From: Richard Aston
Sent: 09 November 2010 09:40
To: Planning
Subject: FW: Response for planning application: N6/2010/2055/MA
Attachments: 20101108 Former Shredded Wheat Factory Welwyn Garden City E.doc

FULL PLANNING PERMISSION FOR PART DEMOLITION, REPAIR, RESTORATION, EXTENSION AND CONVERSION OF THE FORMER SHREDDED WHEAT FACTORY COMPLEX TO PROVIDE RETAIL (A1 & A3), BUSINESS (B1), HERITAGE CENTRE (D1), ENERGY CENTRE, NEW LEISURE CENTRE BUILDING AND CIVIC SQUARE BUILDING INCLUDING RESIDENTIAL AND RETAIL (A1 TO A5). ASSOCIATED ALTERATIONS TO EXISTING VEHICULAR AND PEDESTRIAN ACCESS AND HIGHWAY LAYOUT WITHIN AND AROUND THE SITE, INCLUDING THE CREATION OF TWO VEHICULAR ACCESS RAMPS TO BASEMENT PARKING, HARD AND SOFT LANDSCAPING, THE PROVISION OF A CIVIC SQUARE, PARK, PUBLIC AND PRIVATE OPEN SPACE, PEDESTRIAN WALKWAYS TO INCLUDE THE UPGRADE OF THE EXISTING PEDESTRIAN FOOTPATH OVER THE RAILWAY LINE AND ASSOCIATED ENABLING WORKS. OUTLINE PLANNING PERMISSION FOR DEVELOPMENT OF LAND TO THE WEST AND SOUTH OF THE SHREDDED WHEAT FACTORY TO COMPRISE THE FOLLOWING USES: RETAIL (A1 & A5), BUSINESS (B1), HOTEL (C1), RESIDENTIAL, TO INCLUDE: HOUSES, FLATS, CARE HOME AND YMCA (C2 & C3); DOCTORS SUR

BROADWATER ROAD WEST, WELWYN GARDEN CITY  
 DETAILED PROPOSALS: LEISURE CENTRE (BUILDING A)  
 PROPOSED PLANS  
 568\_07\_210

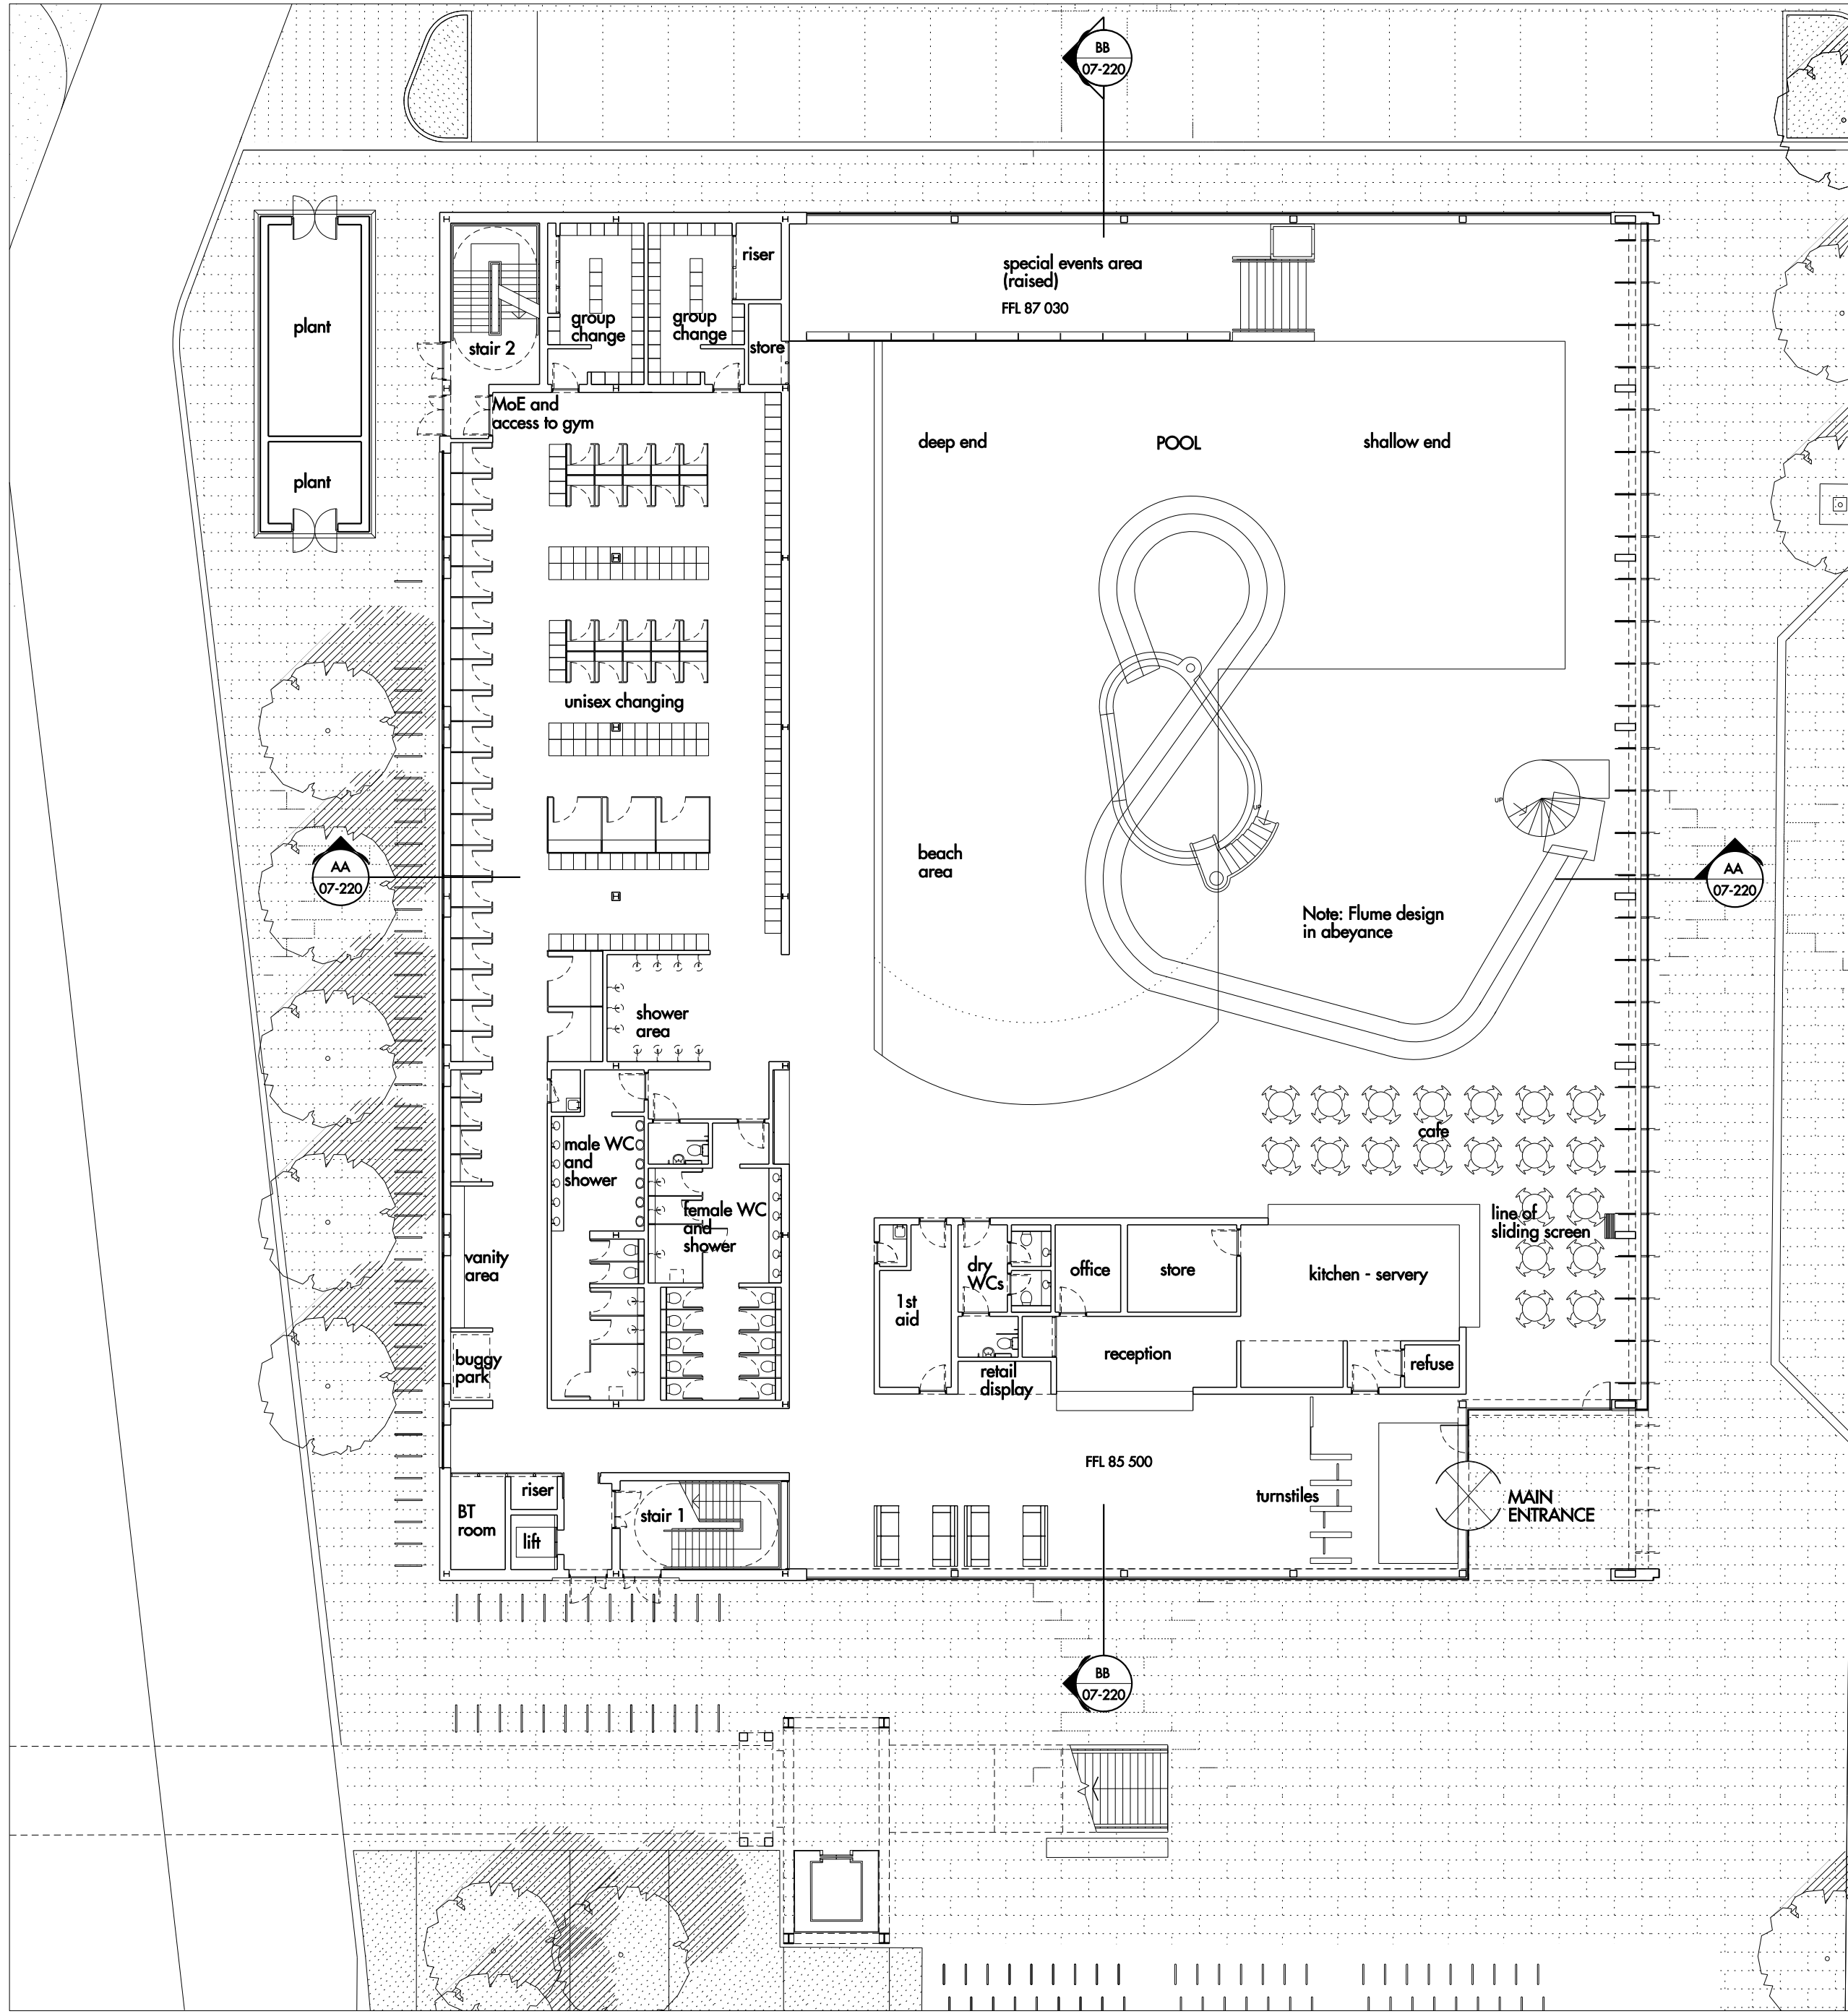
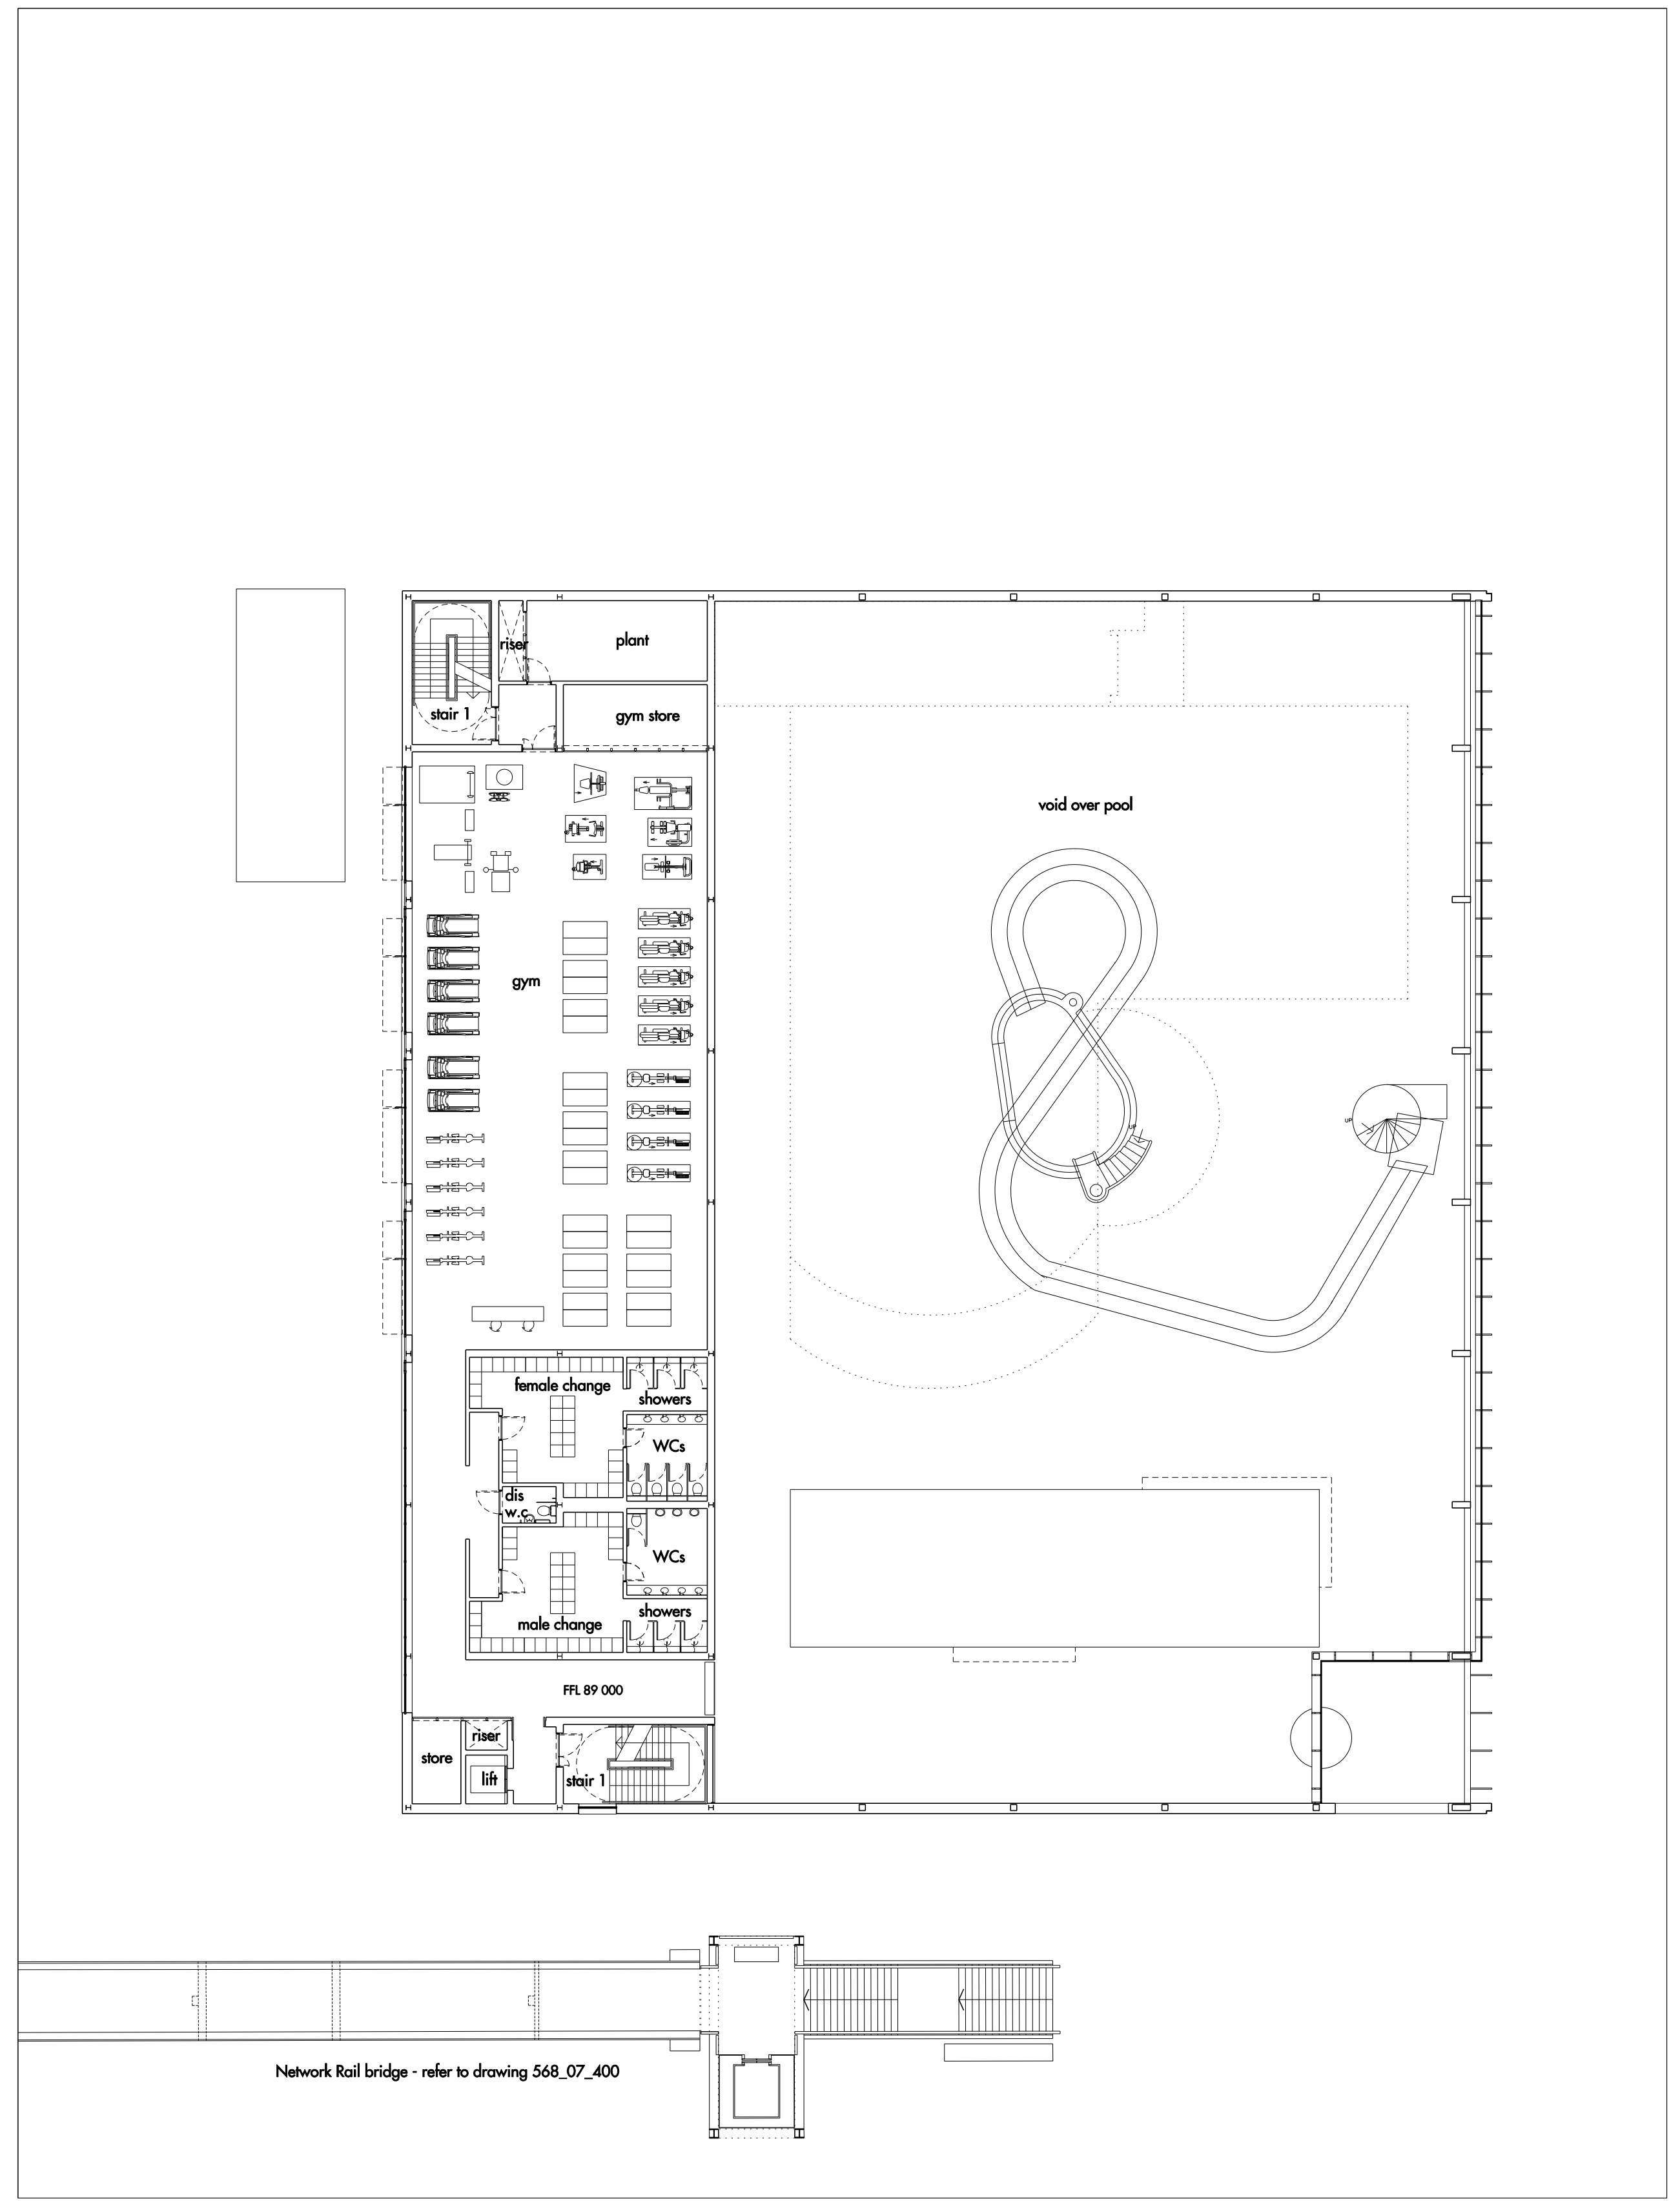
- Sport England promote the use of a draft lobby at the main entrance to aid the reception environment.
- The turnstiles would normally be post reception, in order to allow access to the reception whilst also maintaining control of access to the building
- It is recommended that the first aid room has a direct exit to the outside so that a casualty can be loaded directly into the ambulance. This would require a change of location.

- The pool is currently designed to accommodate both lane and leisure swimming – does this reflect local need? Can the pool deliver on the learn to swim priorities that may be required locally through educational need and community need with the current design?

- If the swimming pool is to remain as proposed it is suggested that the swimming pools would benefit from being the other way round i.e. with the 25m run being parallel to the changing rooms (shallow end at the entrance end). This will allow people that bring other people to learn to swim classes to be able to observe what is happening from the seating in the café area.

- In relation to the 25m section of the pool the flume should be moved so it does not go over this at all (it is thought that there is room to achieve this) and the raised section (labelled events) at the deep end should remain at a similar level (deck level) all around the swimming pool – both of these points relate to access and sight lines for staff, particularly when the swimming pool is in use for club/teaching, when good contact between staff on the poolside and those in the water is required

- The proposed width of the 25m section of the pool is 12m. Sport England's Swimming Pool Design guidance document (referenced above) recommends that the width of a 6 lane pool should be 13 metres wide while the width of a 5 lane pool should be 10.5 metres

- It would appear that spectators are encouraged to be on poolside and use toilets that lead from the pool surround. It can not be understood from the detail provided how these areas are separated (if at all) but this would encourage contamination, as would the food serving area, into the wet side if not carefully managed

- Changing spaces – the current level of provision is 94 plus group change. Based on the volume of water space provided approximately 190 change spaces are needed to cope with average demand. This is based on the calculation model identified in the guidance (link provided above). This needs to be considered alongside the programming of the facility to feel confident that any final proposals can accommodate user numbers.

- Toilets - In terms of toilet provision, the current level of provision is 13 WC's and 6 urinals. For the amount of water space proposed 10 WC's and 6 urinals are required.

- Showers – currently 17 are provided, this could be rationalised to 12 to 14. It is recommended that all showers are provided in central areas and not within toilet areas. This means that they

are accessible by all. It is advantageous to provide some of the showers are cubicle showers to aid privacy. Showers should be centrally located to facilitate both pre and post swim usage.

- An accessible change is required in wet side area.

- An accessible change is required in dry side and not just a toilet.
- In terms of layout this is not ideal. The toilets should be accessed first. This allows those users who are not getting changed to access the toilets. This then leads to the change area with showers at the rear. With the current proposed layout anyone wishing to use the toilet will have to access the change

- In terms of capacity, the usable space in each is around 34 (this is presuming that each square within the changing rooms on plan Detailed Proposals: Leisure Centre (Building A) Proposed Plans (568_07_210) are changing spaces as apposed to lockers). 1 change space per gym station or 1 change space per 5 sqm of gym floor space are the recommended ratios. The proposed dry side changing areas therefore currently represent an over provision

- There are currently 6 showers proposed. 1 shower per 6 change spaces is the recommended ratio. The proposed provision of showers therefore currently represents an under provision (as mentioned above, this is presuming that each square within the changing rooms are changing spaces as apposed to lockers)

- Lockers – these can be provided within the change area or outside. It is recommended to provide small valuables lockers externally to facilitate those not using the change area. Lockers should not be provided behind the changing spaces as this compromises access at peak time. There should be 2.5 lockers per change space to allow for change overs and a number of lockers being out of use. Accessible lockers need to be provided outside of the accessible change

- Natural light should be encouraged whilst avoiding glare
- Views over the pool should be included where appropriate (whilst being aware of child protection issues)
- A plumbed in water fountain should be included to serve the gym

- The toilet located on the second floor needs to be accessible

- There is significant office space on the second floor. This may be useful for centre and local club usage but this needs to be clarified as it is a significant expense to the scheme.
- In relation to the long term sustainability of the proposed Leisure Centre to may be useful to consider the mixture of facilities included i.e. would the inclusion of a larger gym or a dance studio be beneficial from a revenue generation perspective?
